**Subject: The Retreat at TimberRidge Preliminary Plan - Review 1**

This letter responds to your review letter dated May 17, 2018 regarding the subject application. Responses to comments in that letter are shown in **RED** below the original comment.

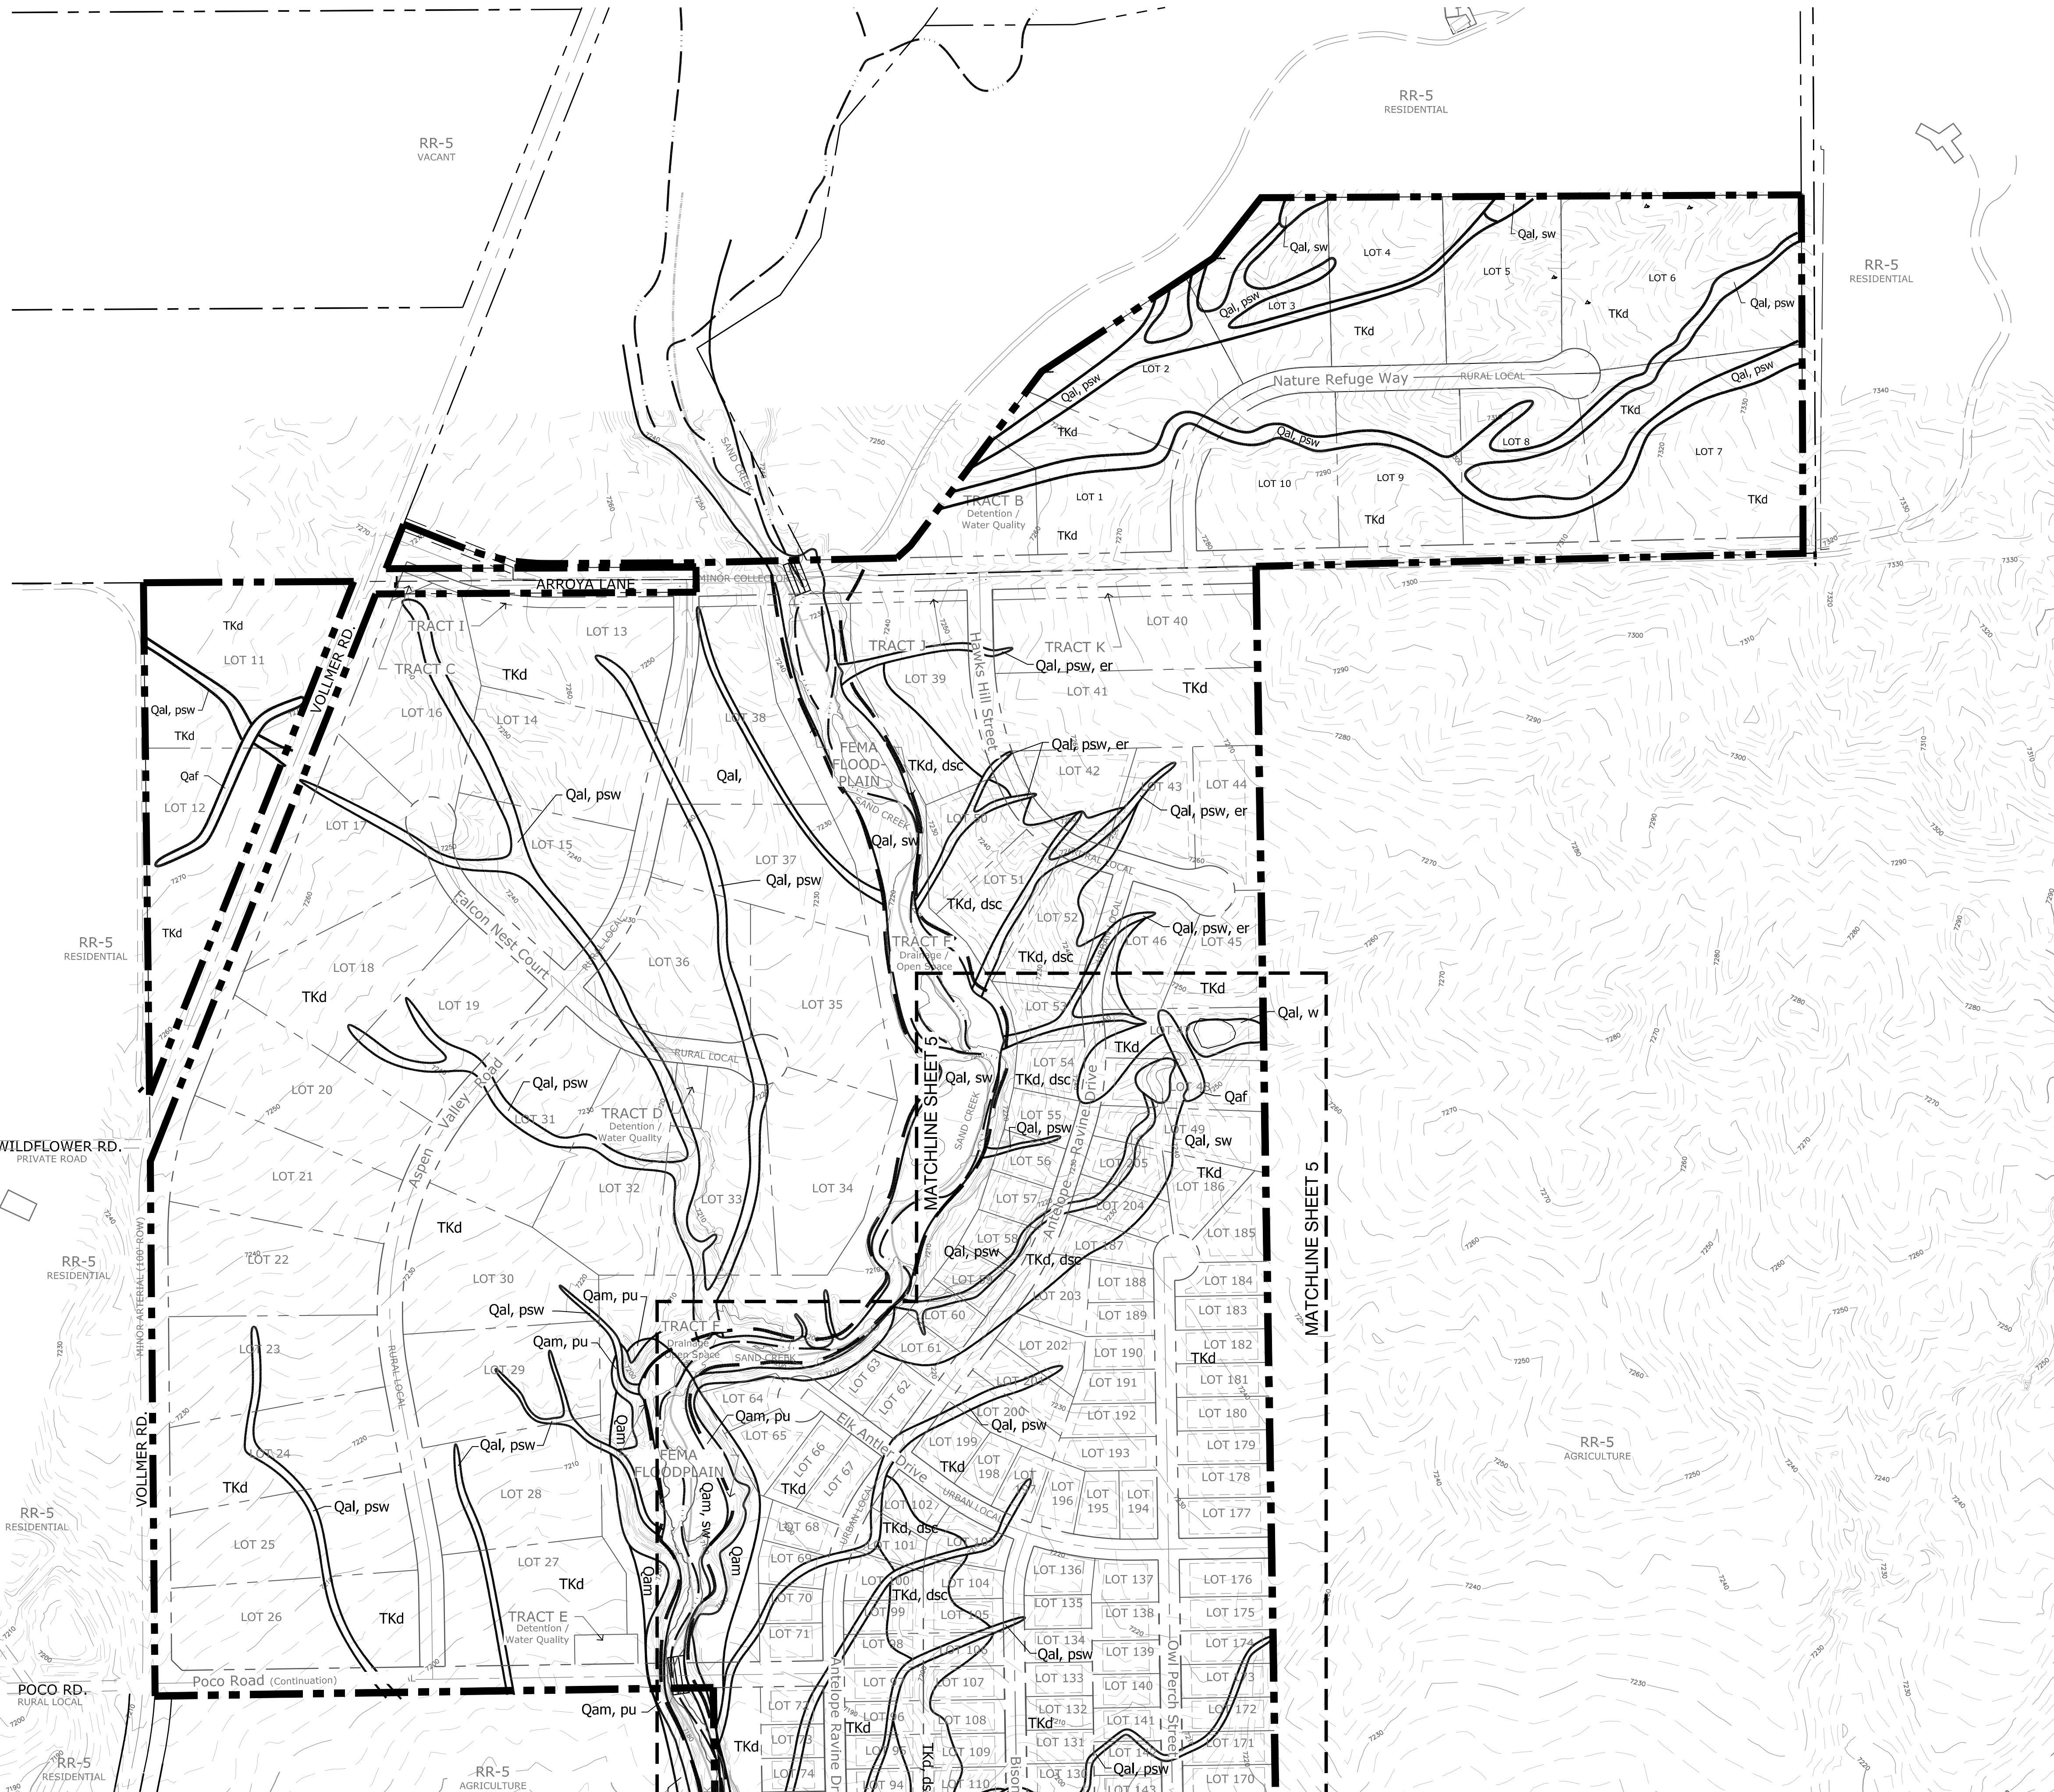
4. The term “floodway” is used to label the floodplain – please verify whether this is the entire floodplain; if so, relabel as “FEMA floodplain”; if not, show and label the entire floodplain as well. **Floodplain labeled as FEMA Floodplain.**

S3 ARROYA LANE INTERIM RURAL LOCAL ROAD SECTION - 80' ROW
SCALE: 1" = 1'-0"

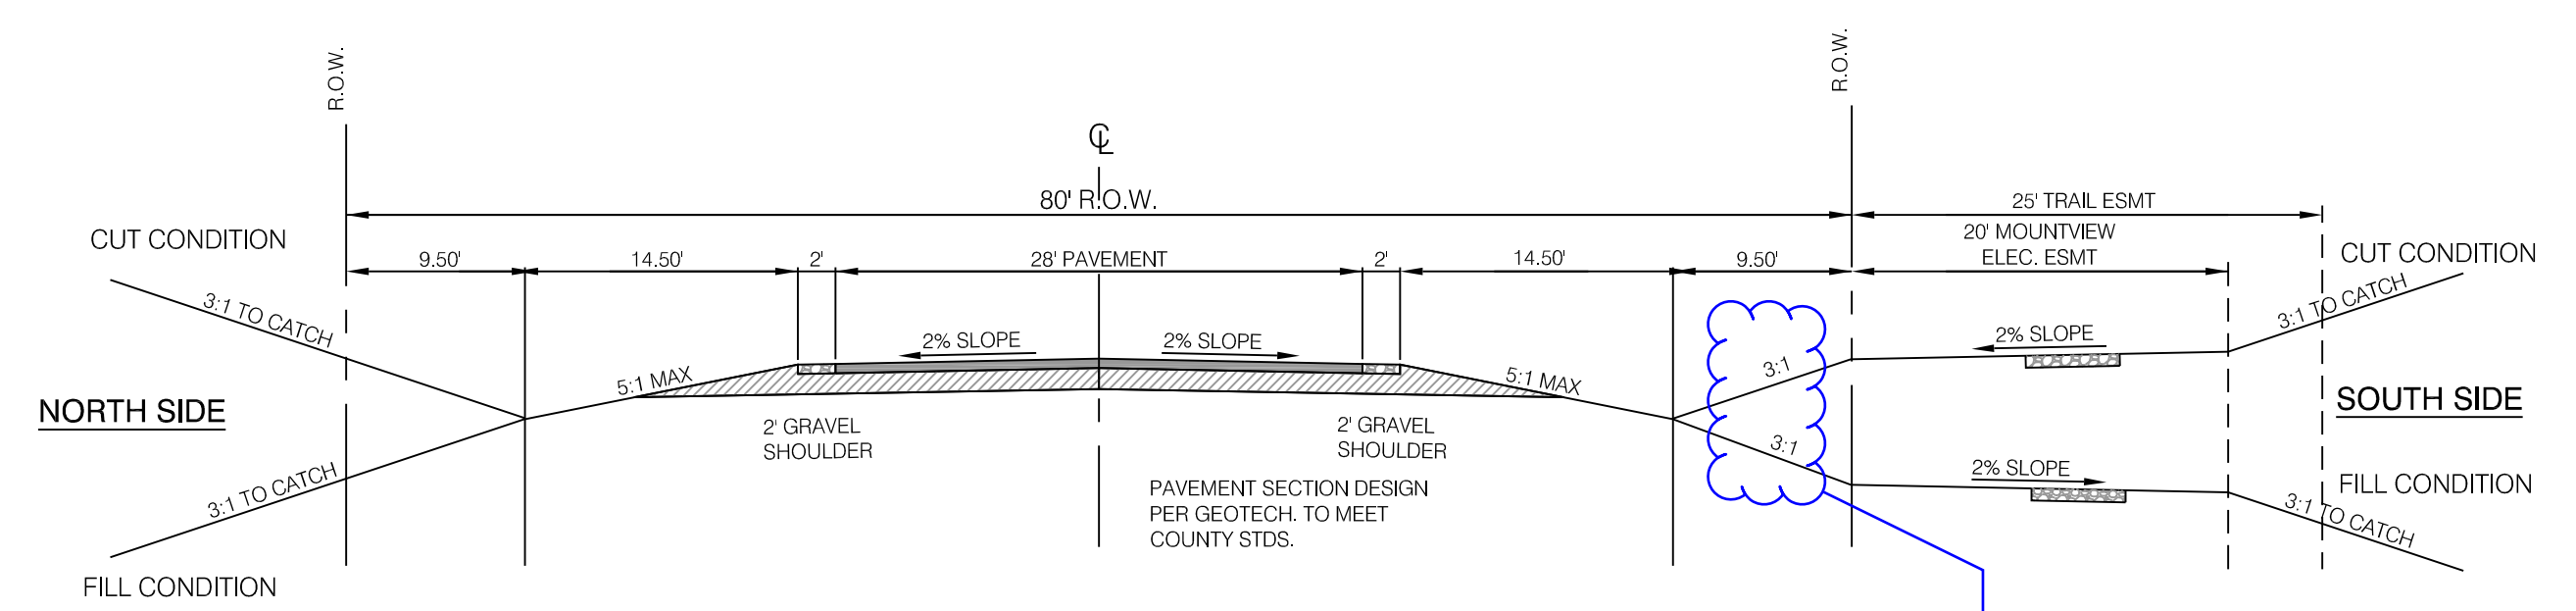
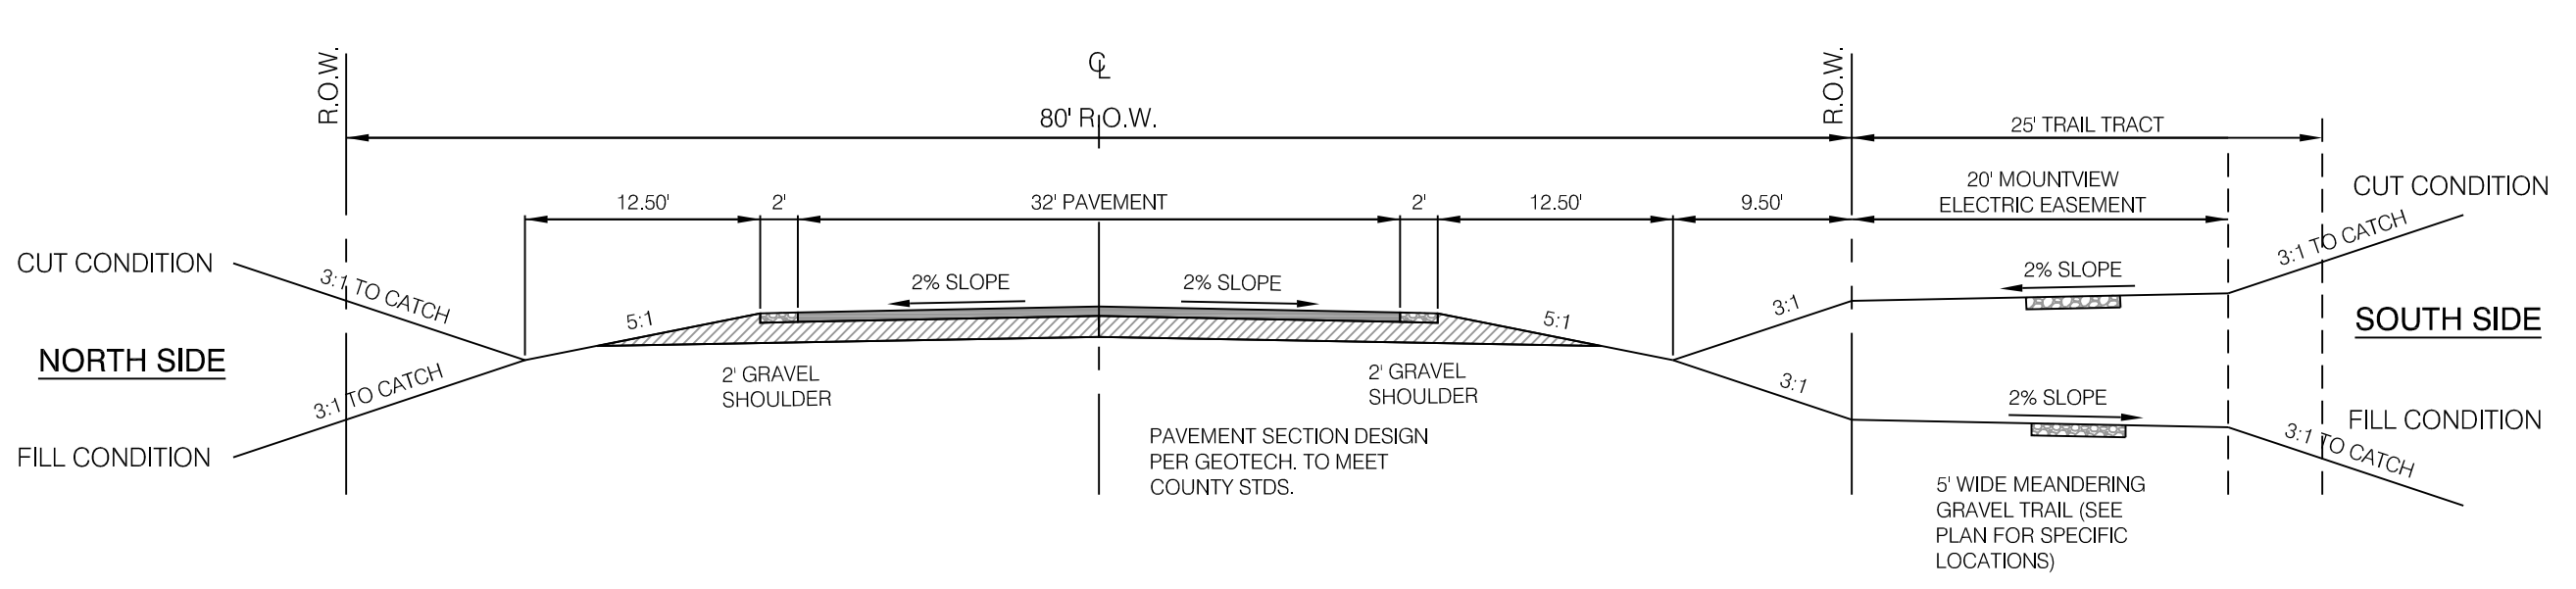
1. See redline on Figure 1 (indicate phase for paving of Arroya Lane).
2. Regarding the five deviation requests:
  - a. ECM 2.2.7.B – Road Paving Policy: The request to construct Nature Refuge Road as a permanent gravel road has been denied. An alternative may be to phase paving and/or defer paving this road until Arroya Lane is constructed and

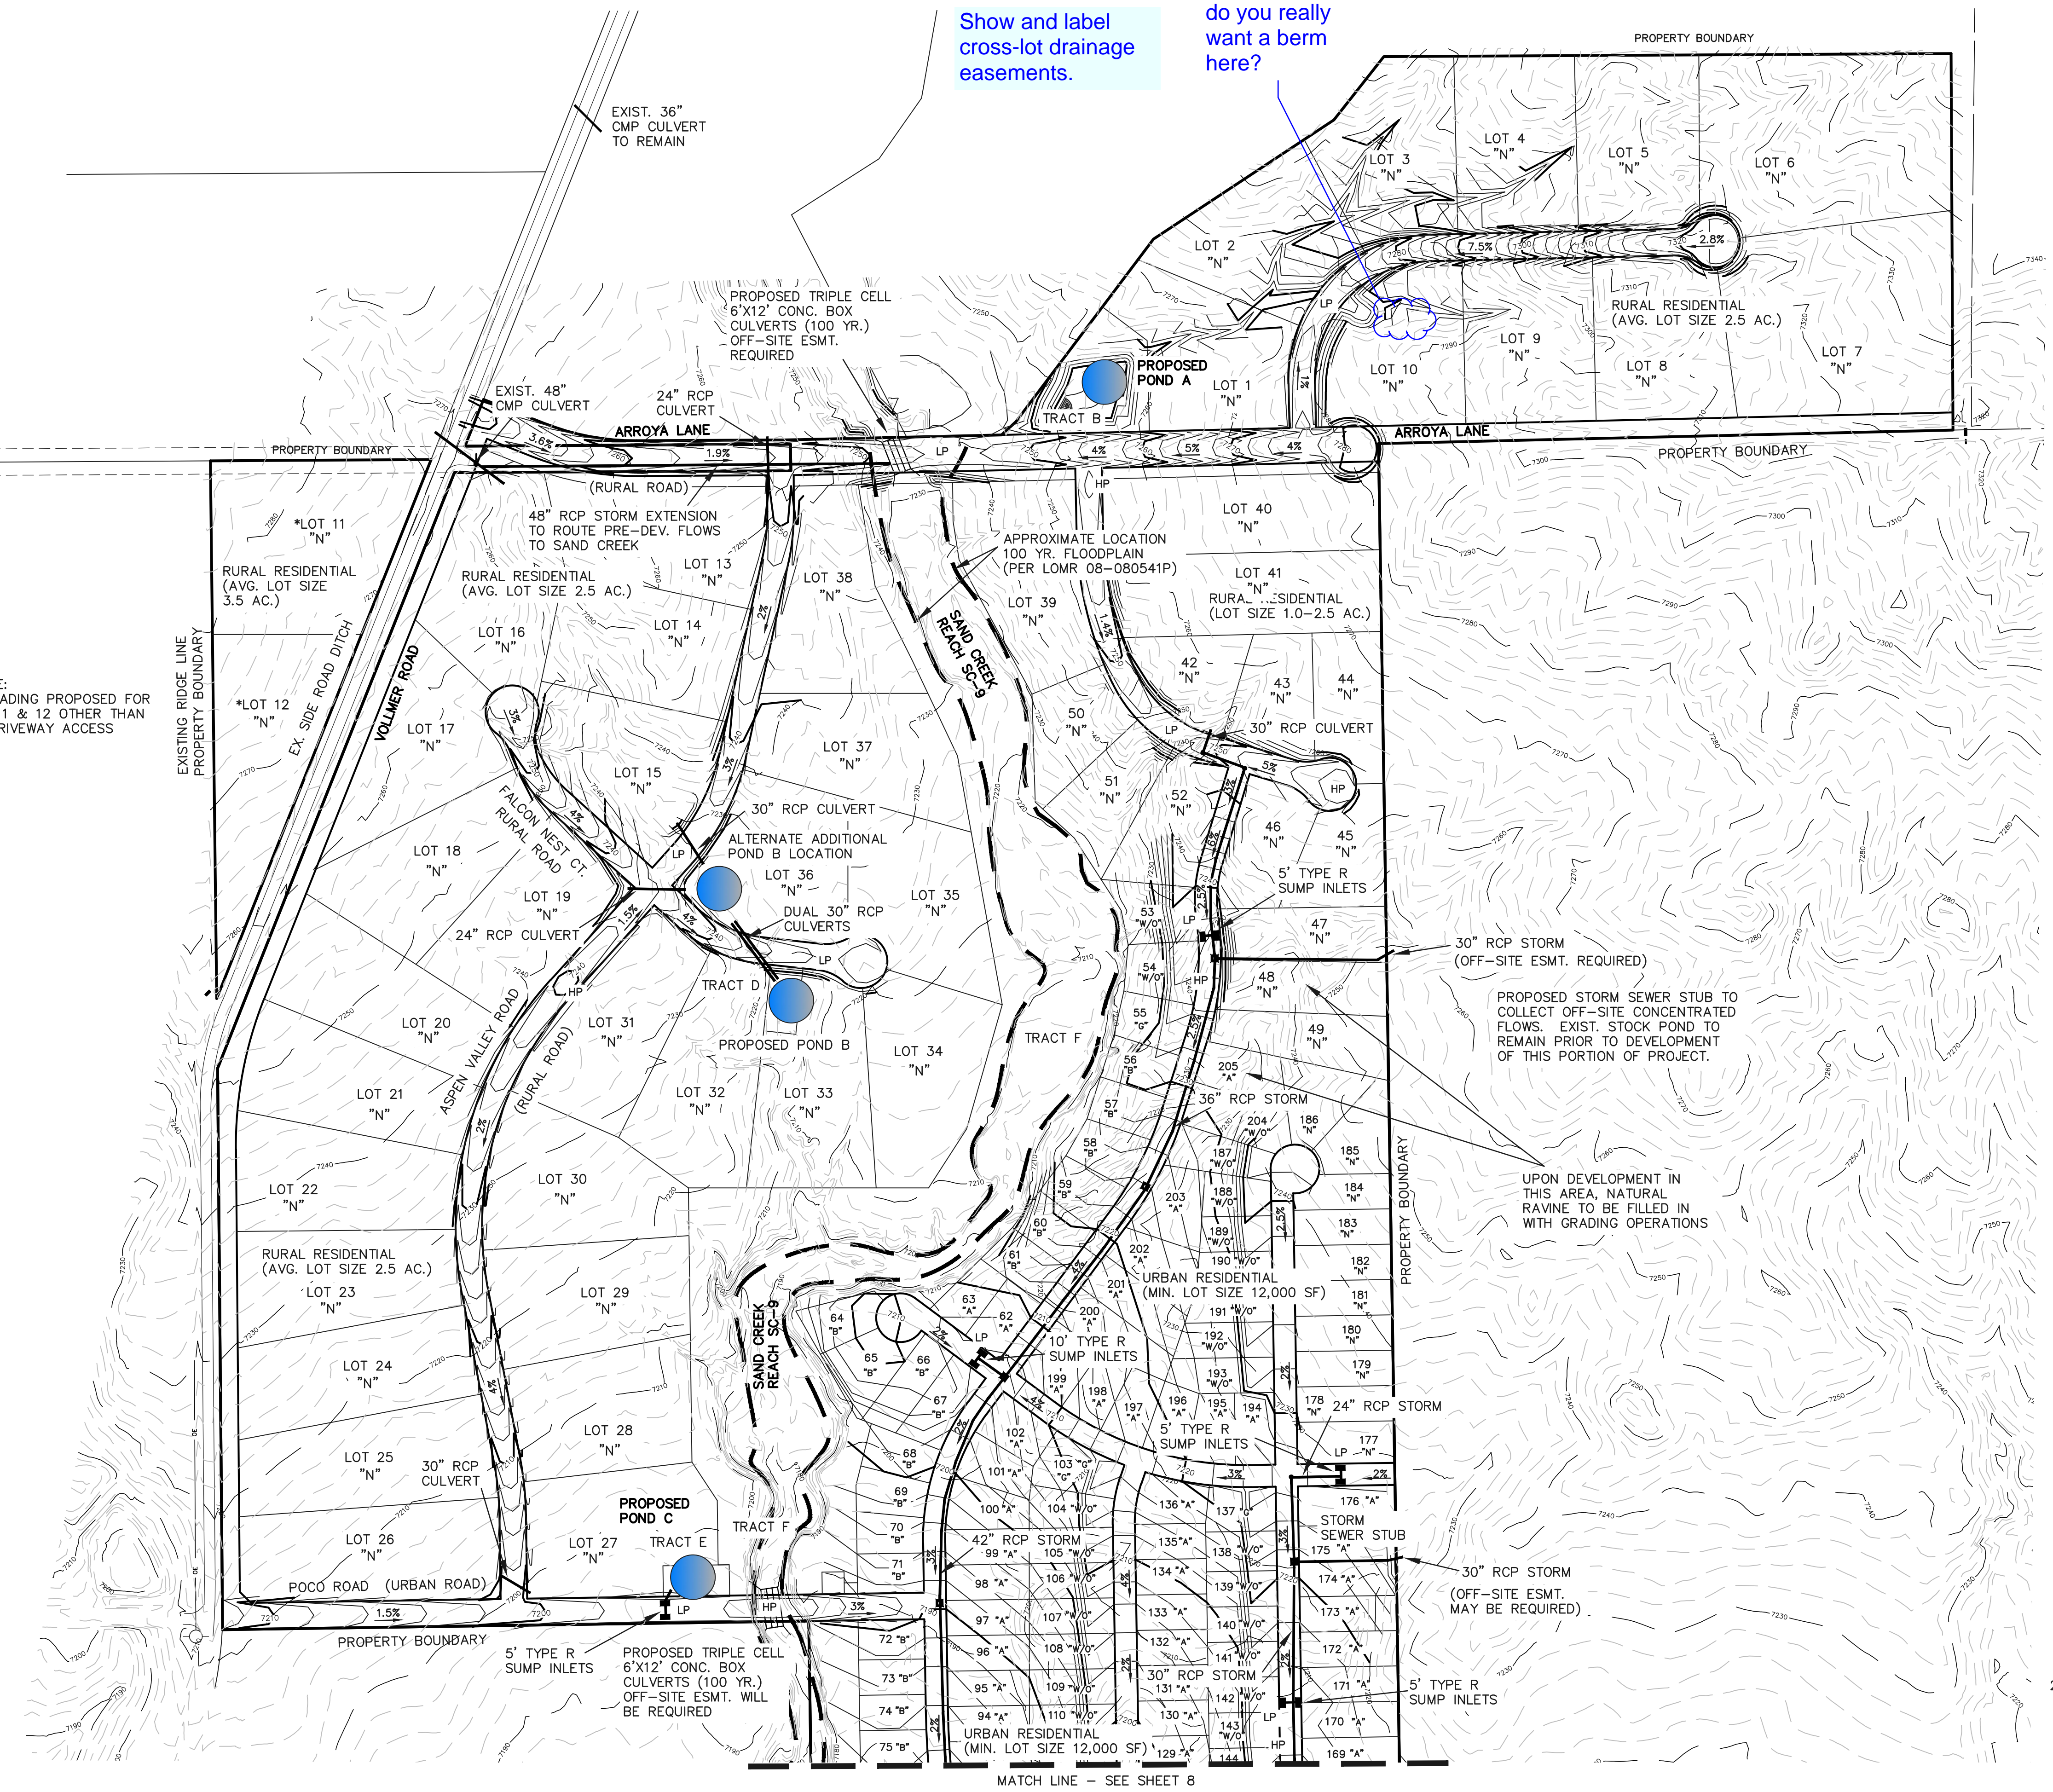
5. Provide a preliminary (not for construction) grading plan for reference. This plan does not require erosion control design or details, but should identify/highlight areas that will need erosion control at some point. (This is being asked for separately, rather than shown on the Preliminary Plan itself, so that the amount of information on the Preliminary Plan drawing does not become excessive.) **A preliminary grading plan has been added to the plan set.**

- c. The location of Alternate Pond B does not look like it would capture all road runoff. Please clarify on drainage and preliminary grading plans. **Now labeled as alternate/additional facility to be determined at Final Plat.**
